Addendum No. 1

RE: Contract ID C202812

Forsyth County (B-4506)

Bridges #319 and 335 Over SR-1620 On US-52

REVISIONS						SHEET NO.
NO.	BY:	DATE:	NO.	BY:	DATE:	S-2
1			3			TOTAL SHEETS
2			4			52

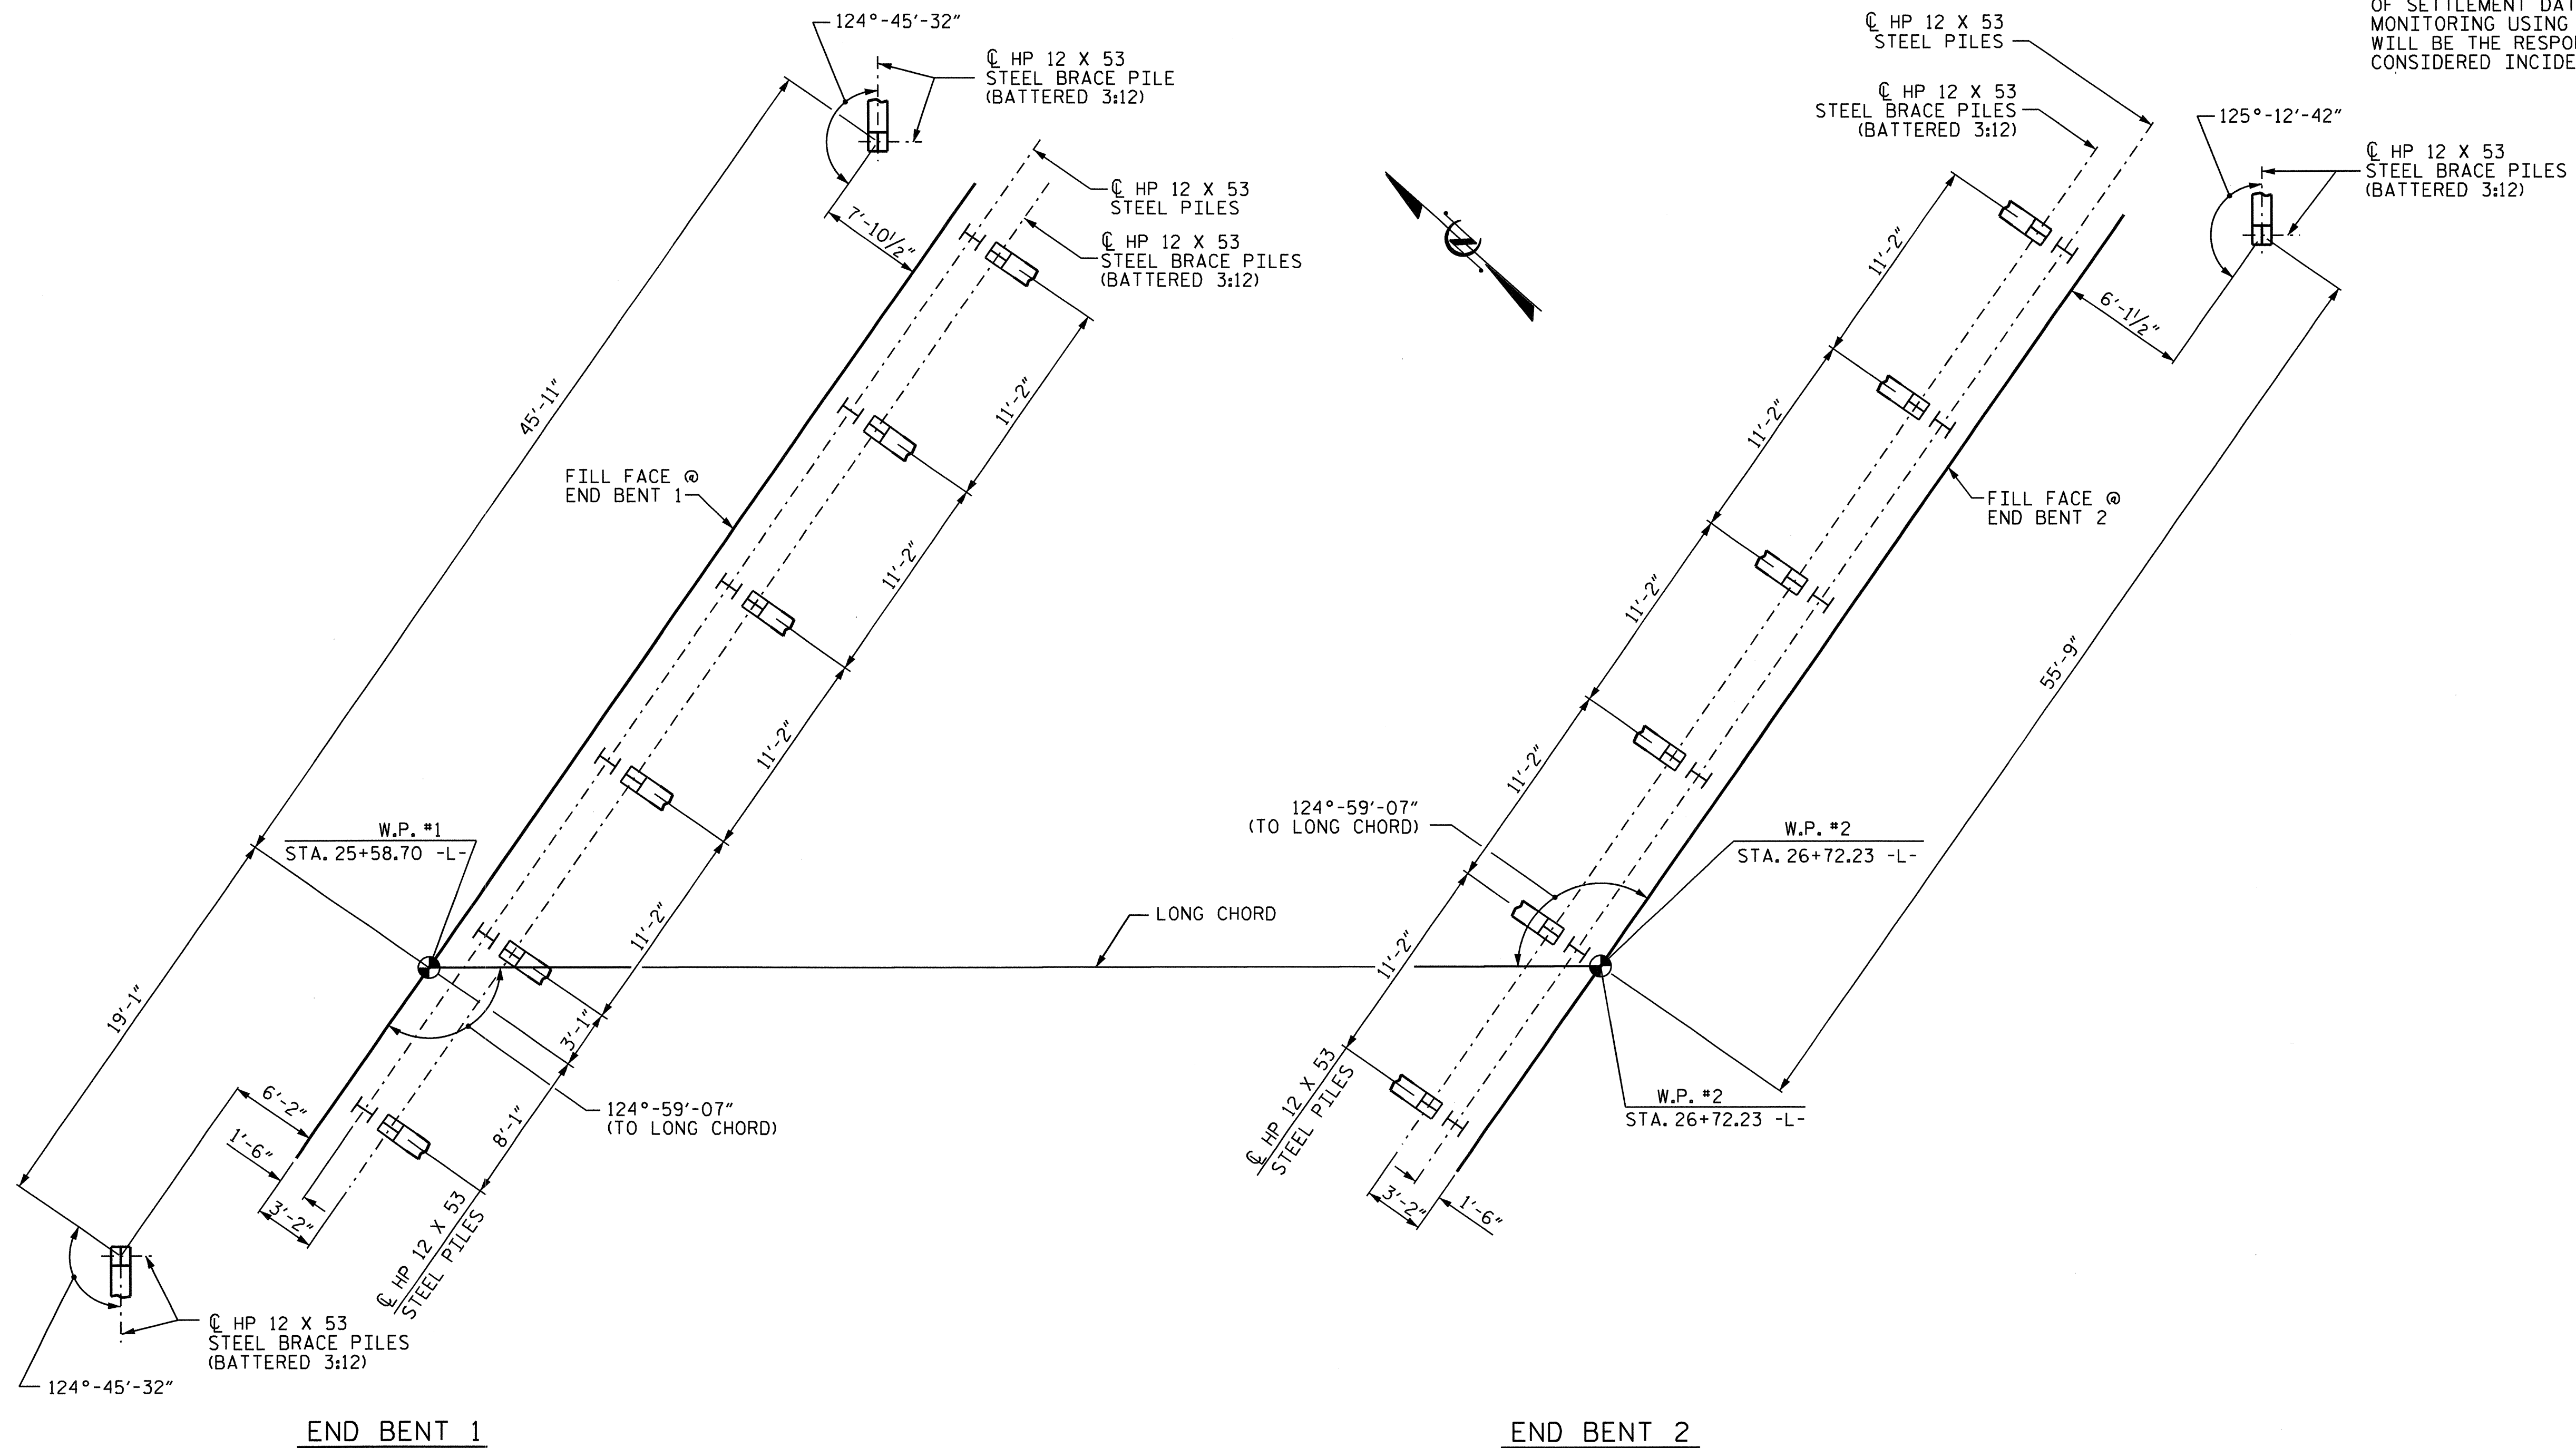
On Sheet Nos. S-2 and S-28 a note was added concerning "waiting periods". Please void Sheet Nos. S-2 and S-28 in your plans and staple the revised Sheet Nos. S-2 and S-28 thereto.
